**Addendum No. 1**

RE: Contract ID C203056  
WBS # 41831.3.1, Etc.  
STP-0046(6), State Funded  
Northampton County (W-5016, R-5519)  
NC-46 FROM THE I-95 SOUTHBOUND RAMPS TO WEST OF SR-1200, AND SR-1200  
FROM NC-46 TO NC-48  
**June 19, 2012 Letting**

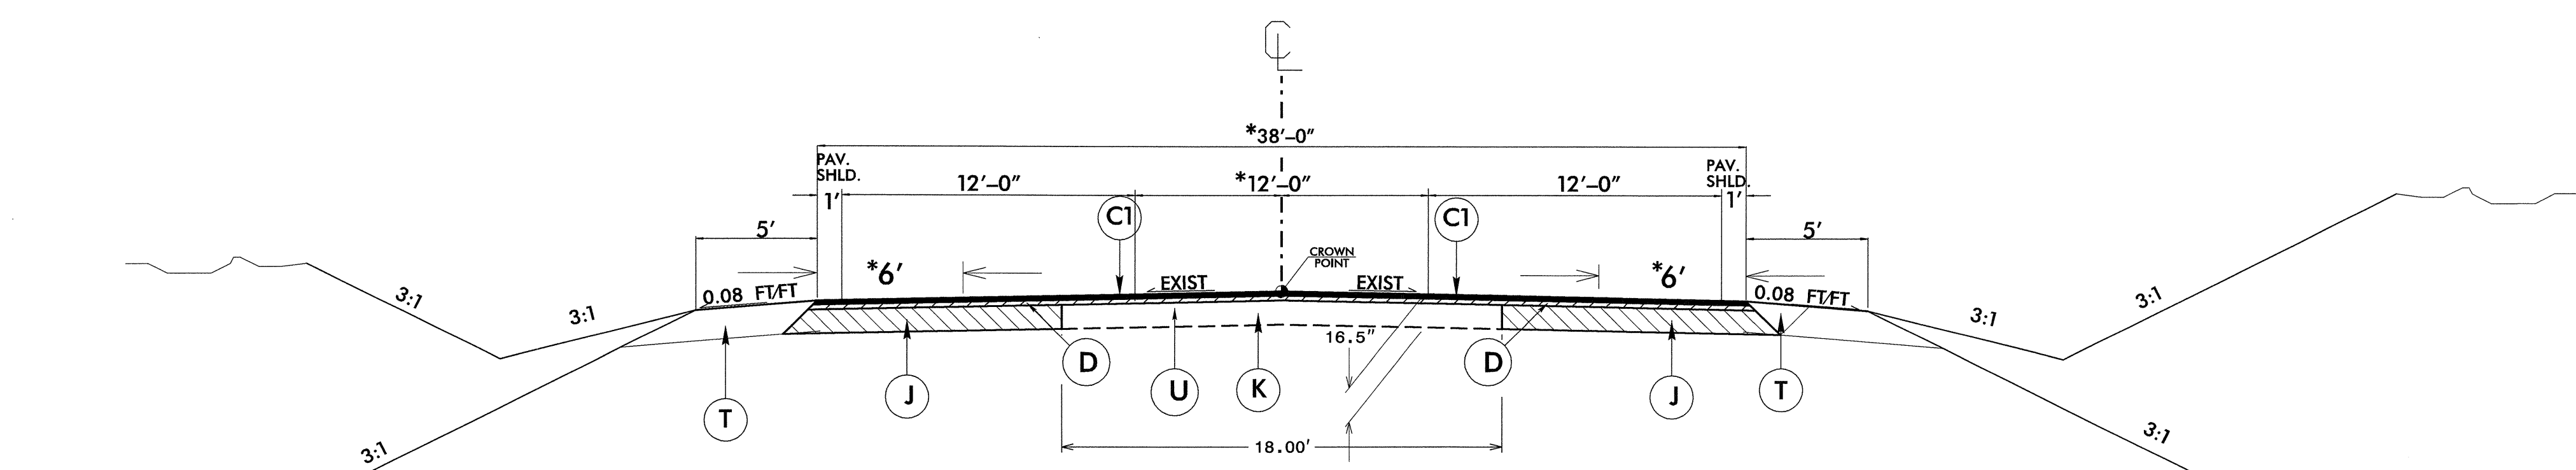
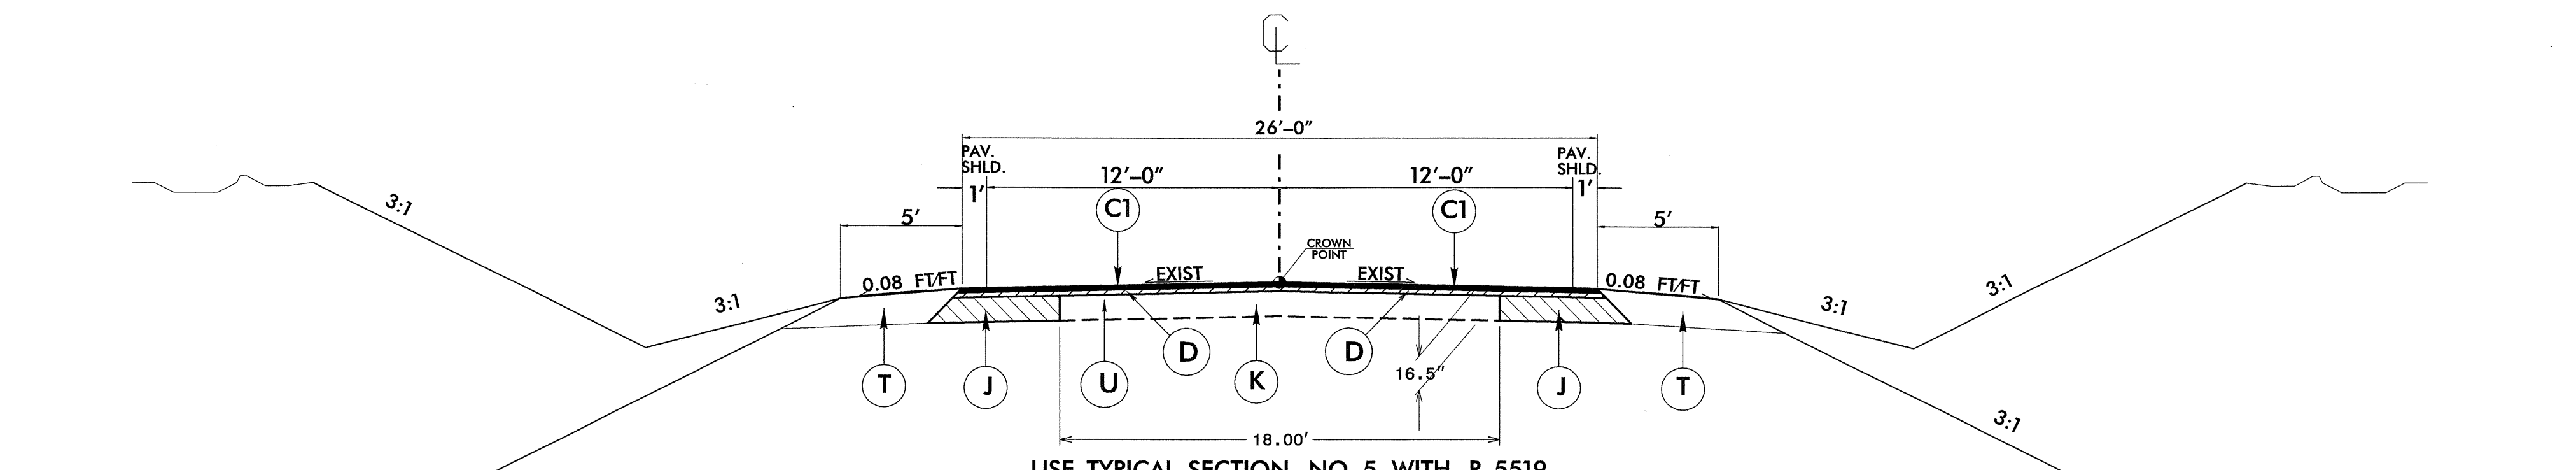
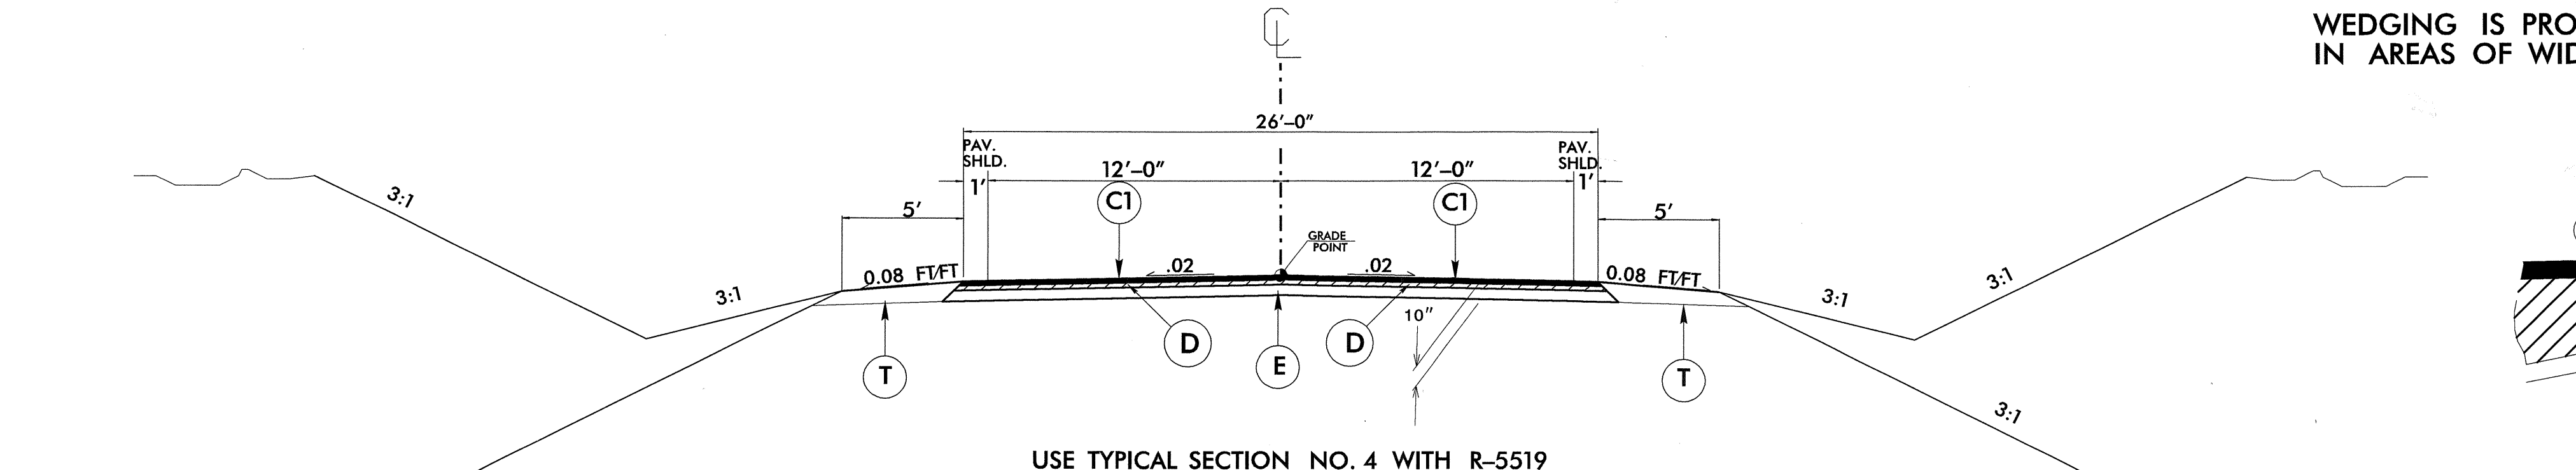
On Sheet No. 2A, Typical 5 and 6 have been revised to correctly show proposed work and the Pavement Schedule has been revised to include J. Please void Sheet No. 2A in your plans and staple the revised Sheet No. 2A thereto.
